Department of Primary Industries

26 APR 2013

**Modification to the Orica Southlands Remediation and Warehouse
Development Project (MP 06_0191 Mod.1)**

Modification to the Orica Southlands Remediation and Warehouse Development Project (MP 06_0191 Mod.1) Comment by NSW Office of Water

Date	Datum	Scale	Size
JAN'13	AHD	1:1000	A1
Drawing Number: 210094-DA-001			Revision B

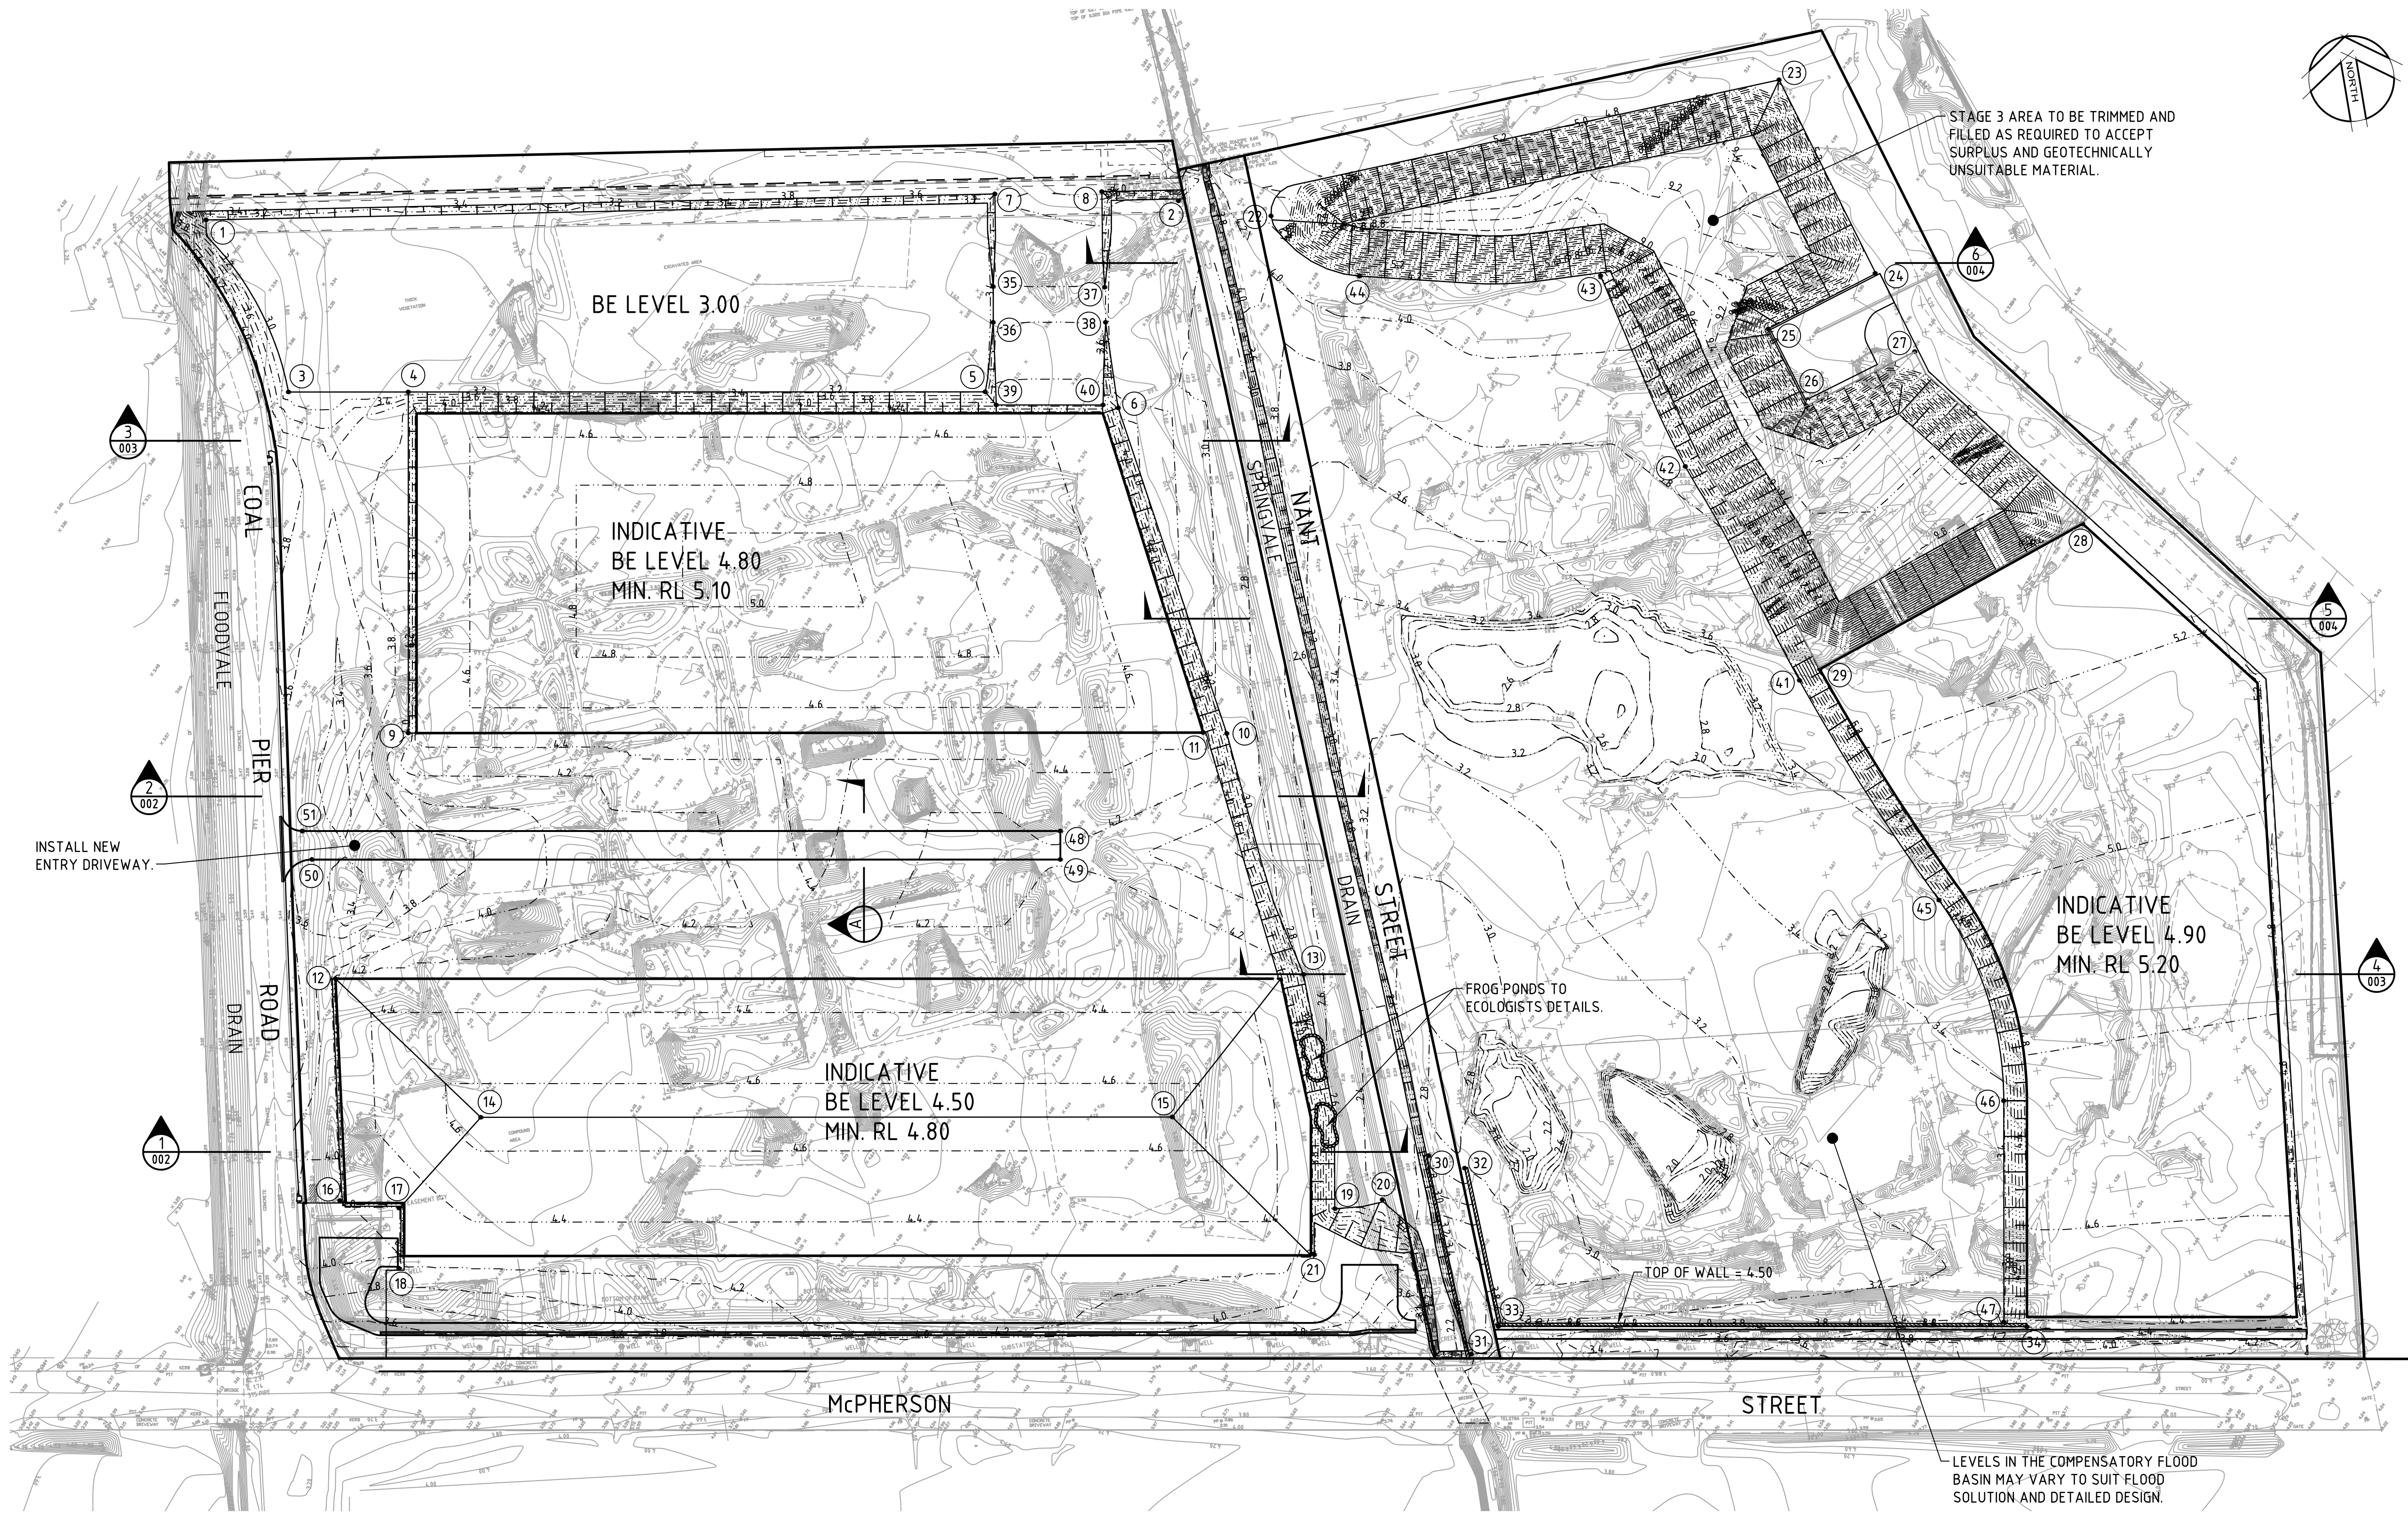
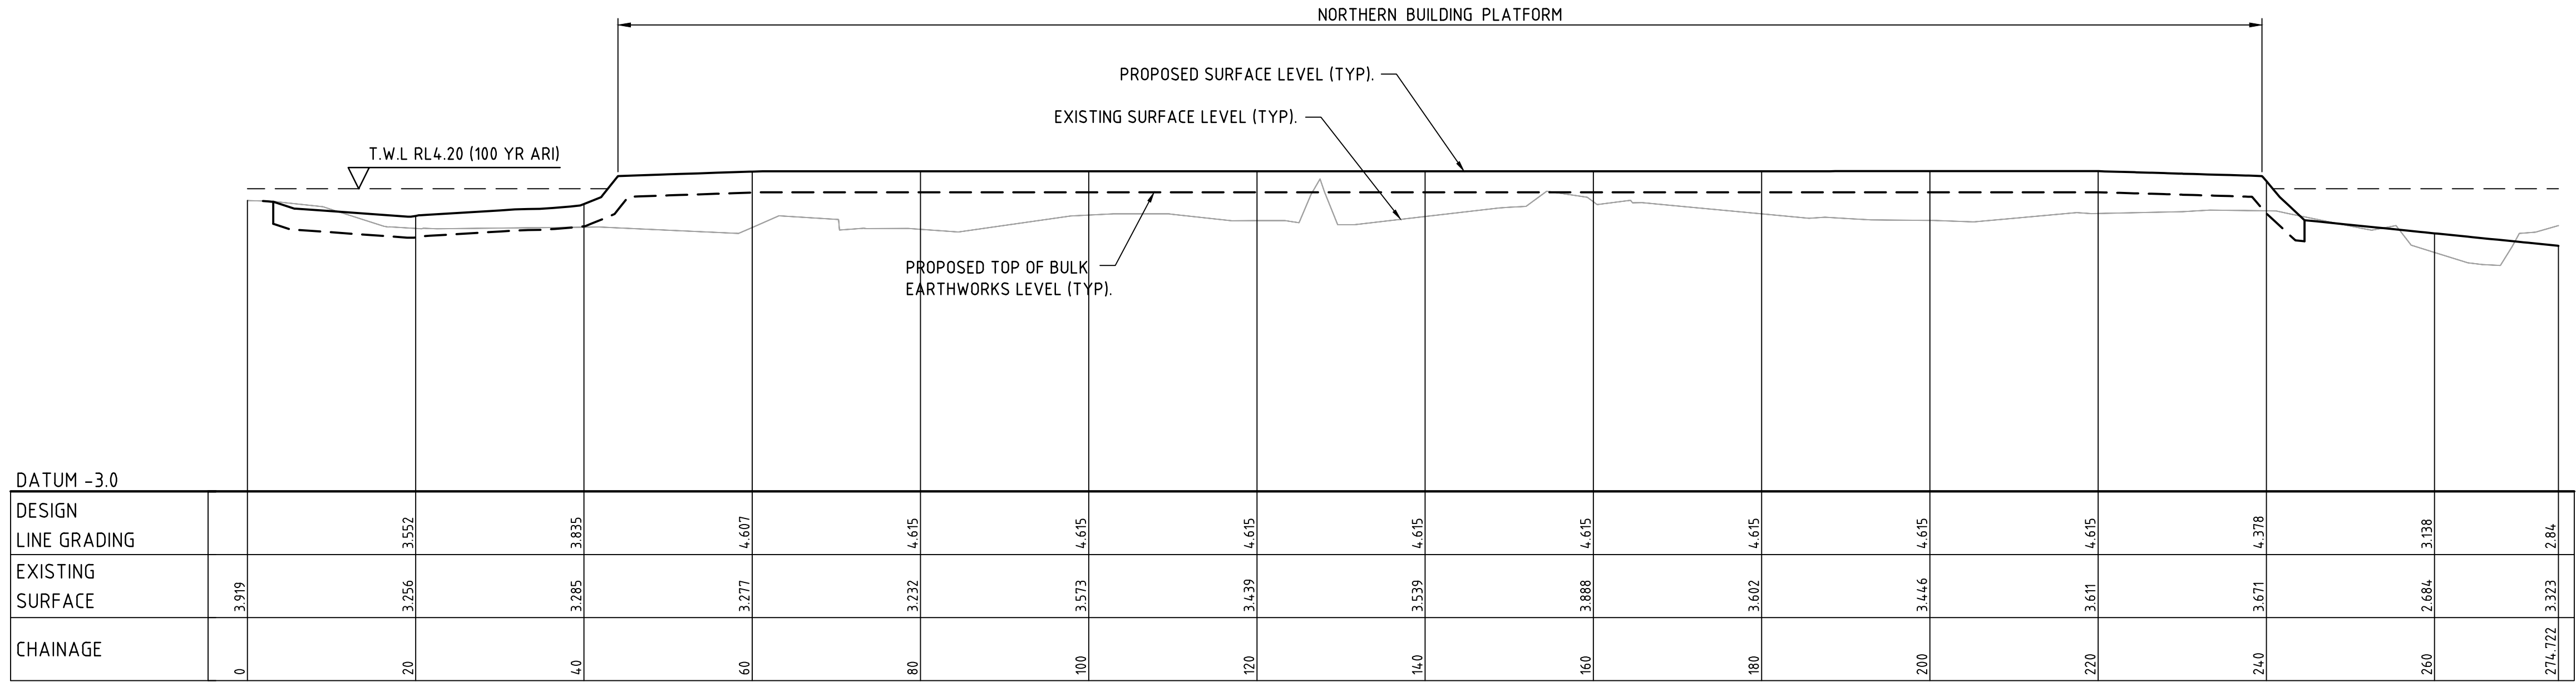
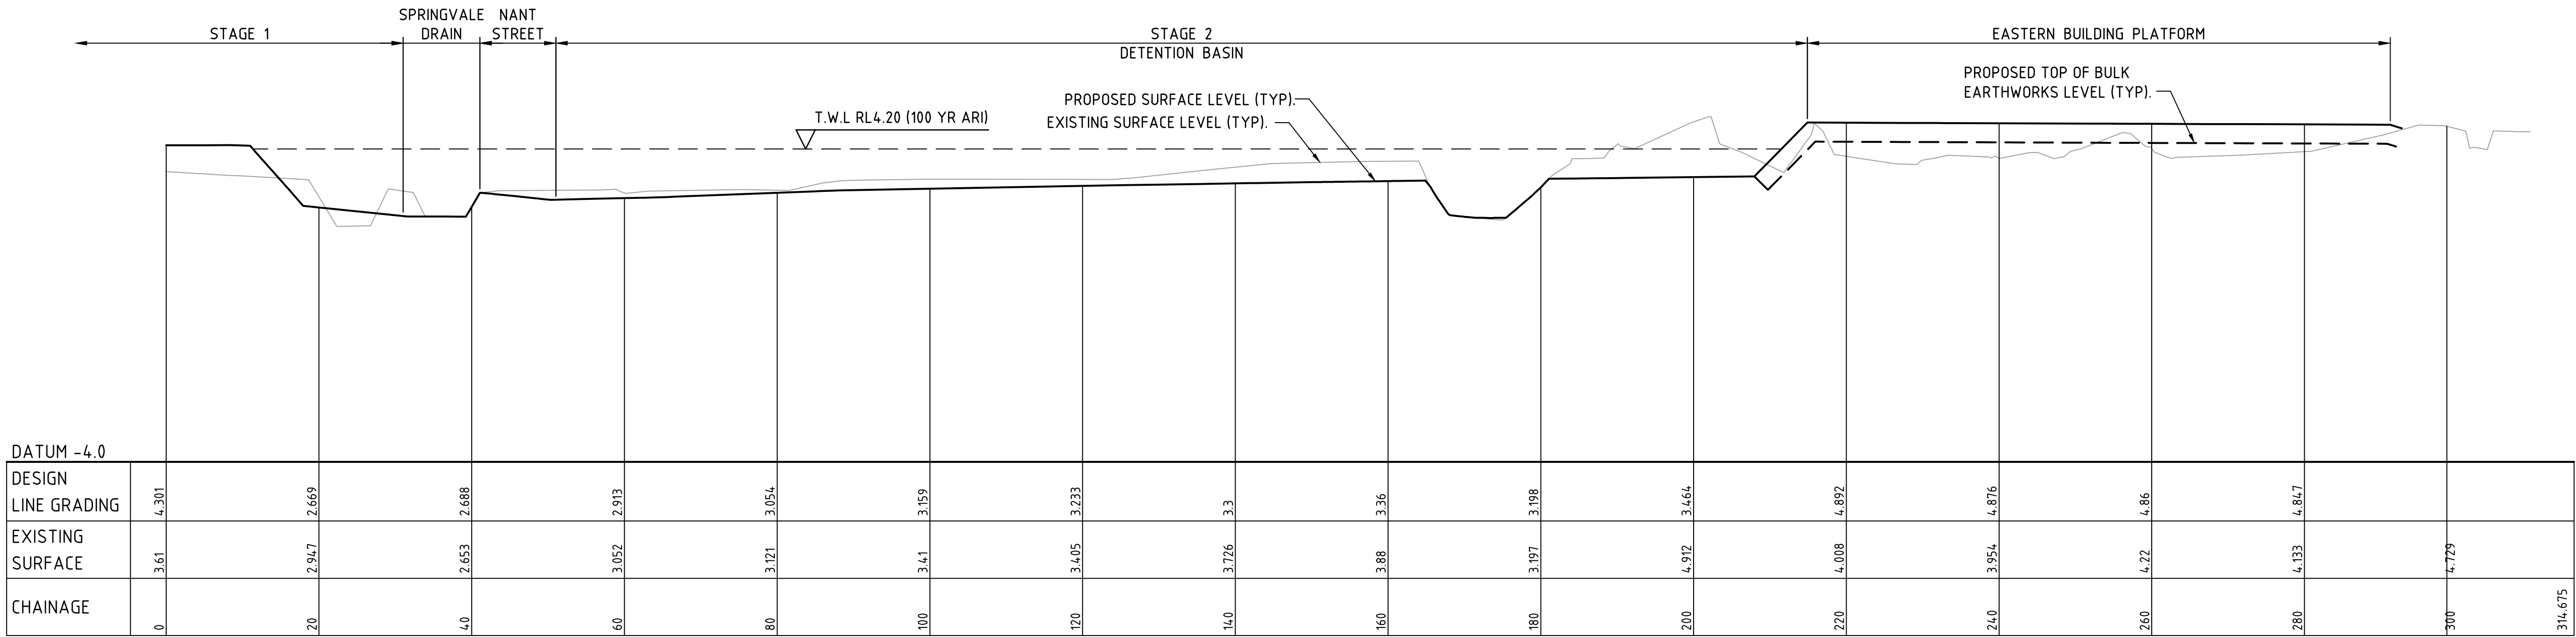
It is noted that the Project Approval dated 16 April 2012 includes an area of Crown land (Springvale Drain, adjacent to Nant Street), and that the proposed modification plans suggest there may be earthworks that will encroach on this area. Any works on this area will require specific approval under the *Crown Lands Act 1989*. No approval should be given to such works where they differ from the original Project Approval without a corresponding landowner consent from the Minister administering the *Crown Lands Act 1989*.

The modification application now seeks to construct compensatory flood storage to the east and west of Springvale drain. It is unclear if the reconfiguration of the flood basin is proposed to be setback from the drain, and if so by what distance. Clarification is therefore requested.
